**WEST SUSSEX COUNTY COUNCIL
PLANNING SERVICES CONSULTATION**

DATE: 20/12/2017

SUBJECT: FG/115/17/PL - 4 No. bungalows.

44, Ferringham Lane, Ferring, West Sussex, BN12 5LU

SCALE 1:200 @ A1
DATE 14.05.2017
DRAWN sed
DWG No. 628-02 rev. C

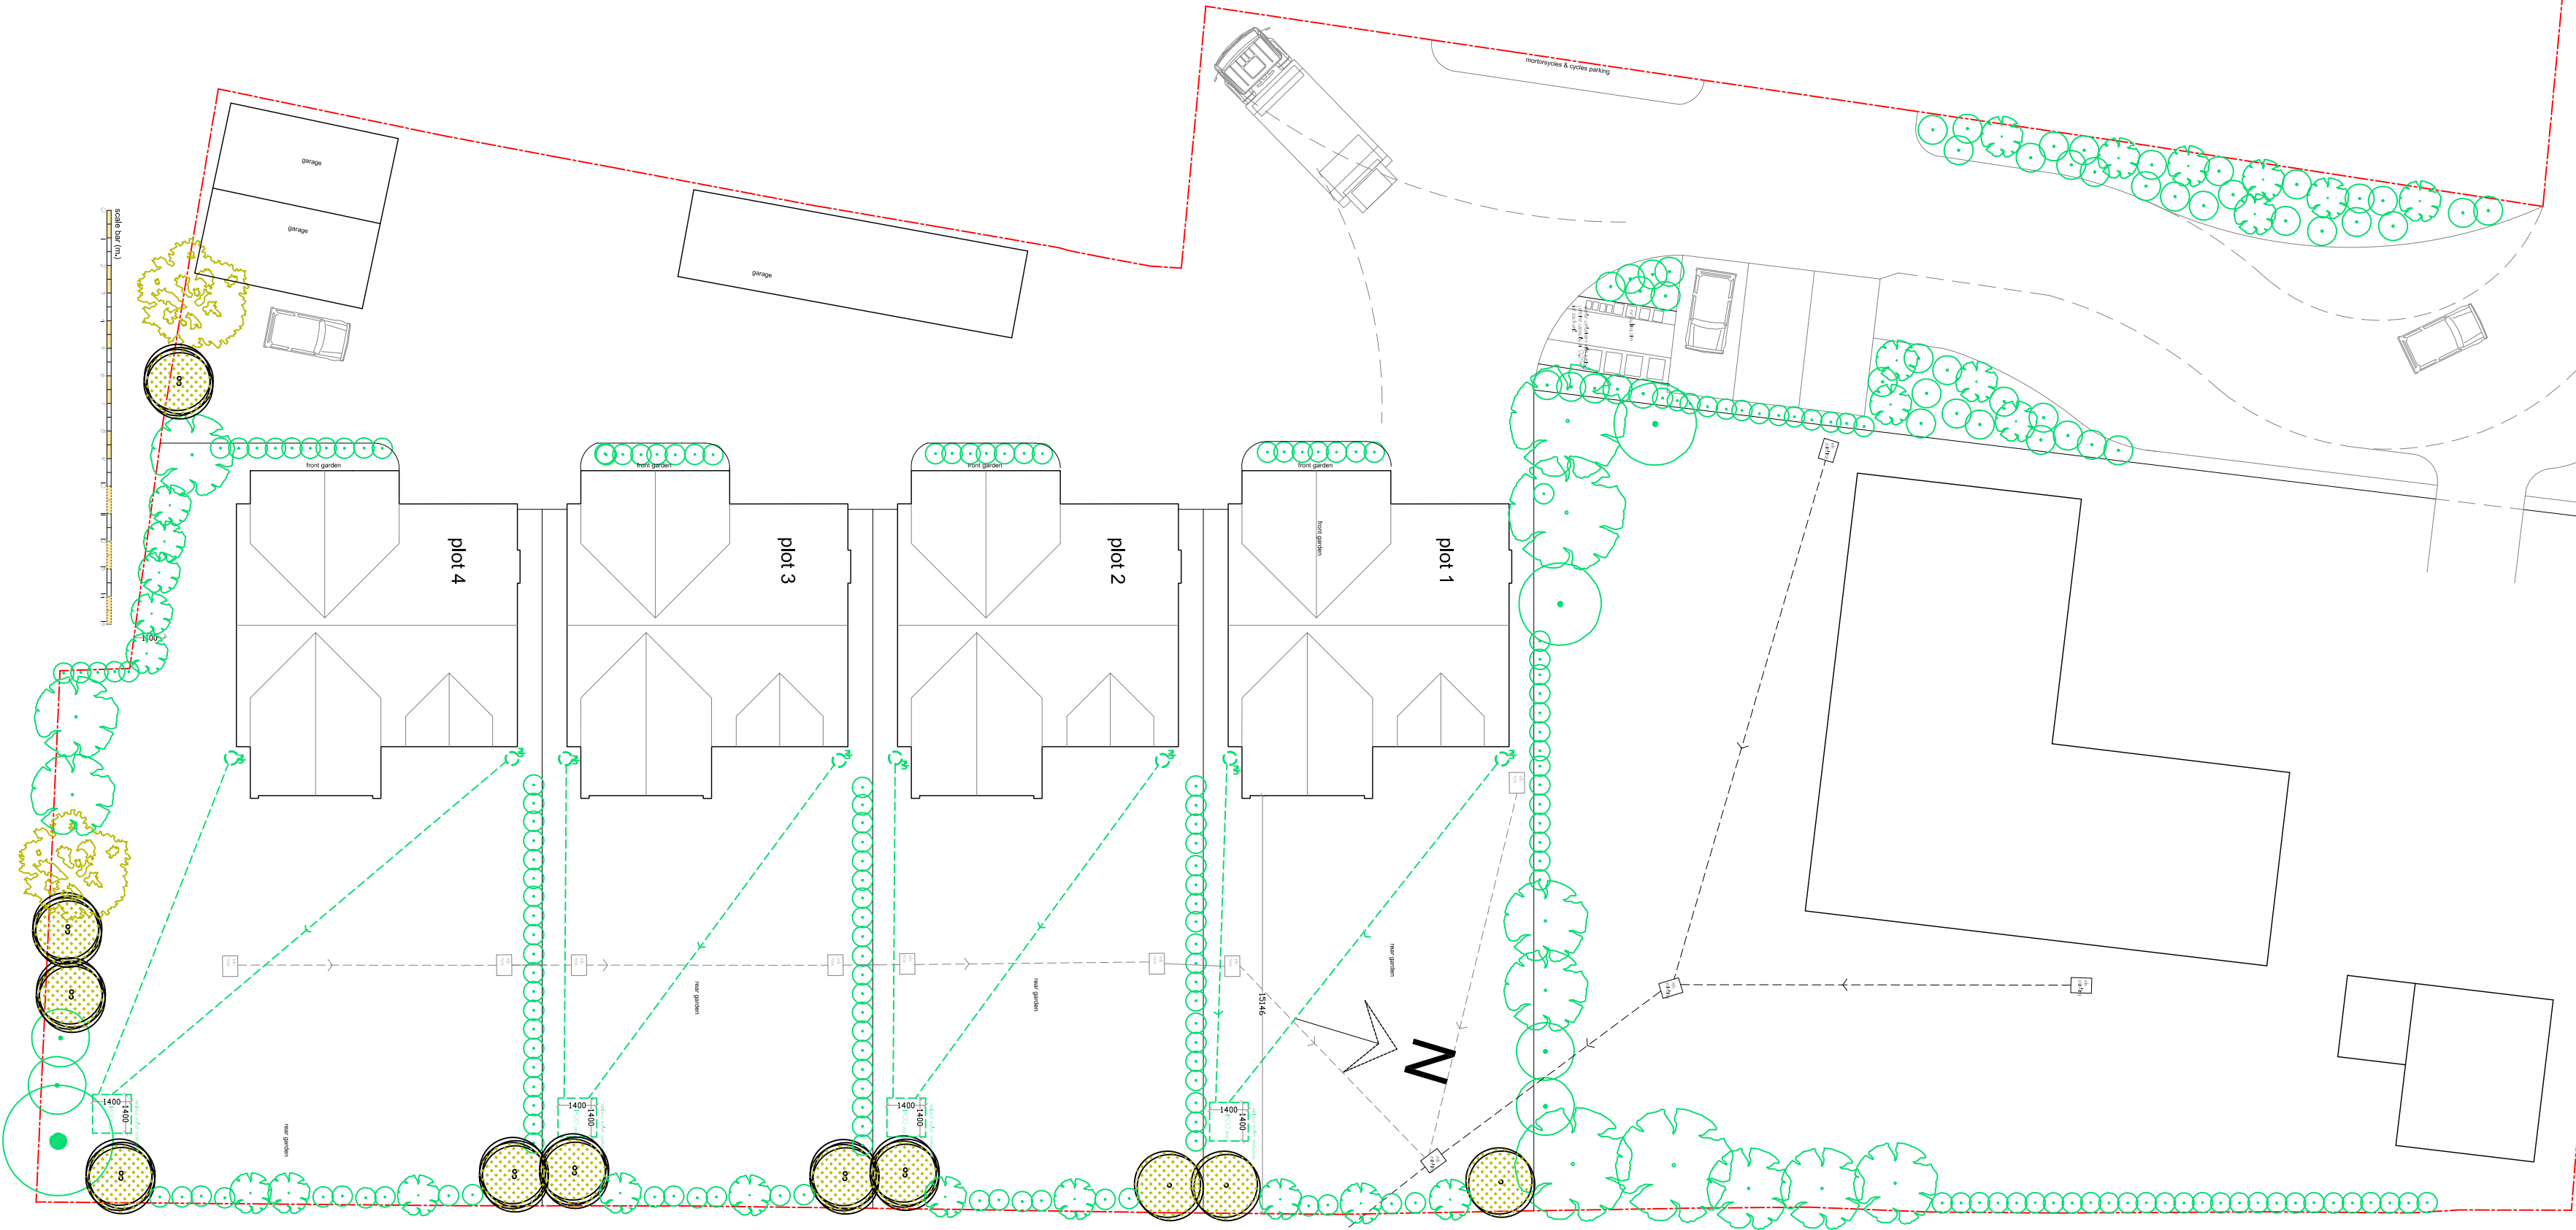
Upon review of these plans the garages have been increased in size to 3 x 6 metres and the dwellings have been repositions further west within in the site.

The garages are now considered to be adequately sized.

The repositioning of the dwelling has resulted in the area of hardstanding parking spaces allocated to each dwelling reduced. Hardstanding parking will now take place in the form of 1 space per dwellings provided in parallel fronting the dwellings.

Typically parallel hardstanding spaces should measure 6.0 metres in length to allow for manoeuvring room into and out of the space. The demonstrated spaces do not meet this guidance and the provision of spaces as shown does seem to restrict access to the dwellings front doors and side access points. The workability of the parking spaces would not be considered a matter for the Local Highway Authority though I can confirm that the provision of each dwelling with a garage and hardstanding space (+ shared visitor spaces) would be considered adequate to meet the demand of the development.

The repositioning of the dwellings may impact the ability for larger vehicles (Fire and Refuse) to turn on site. Swept path tracking plans should be provided to demonstrate that the ability for larger vehicles to turn on site has been retained. This turning area should not use any area allocated for resident parking.
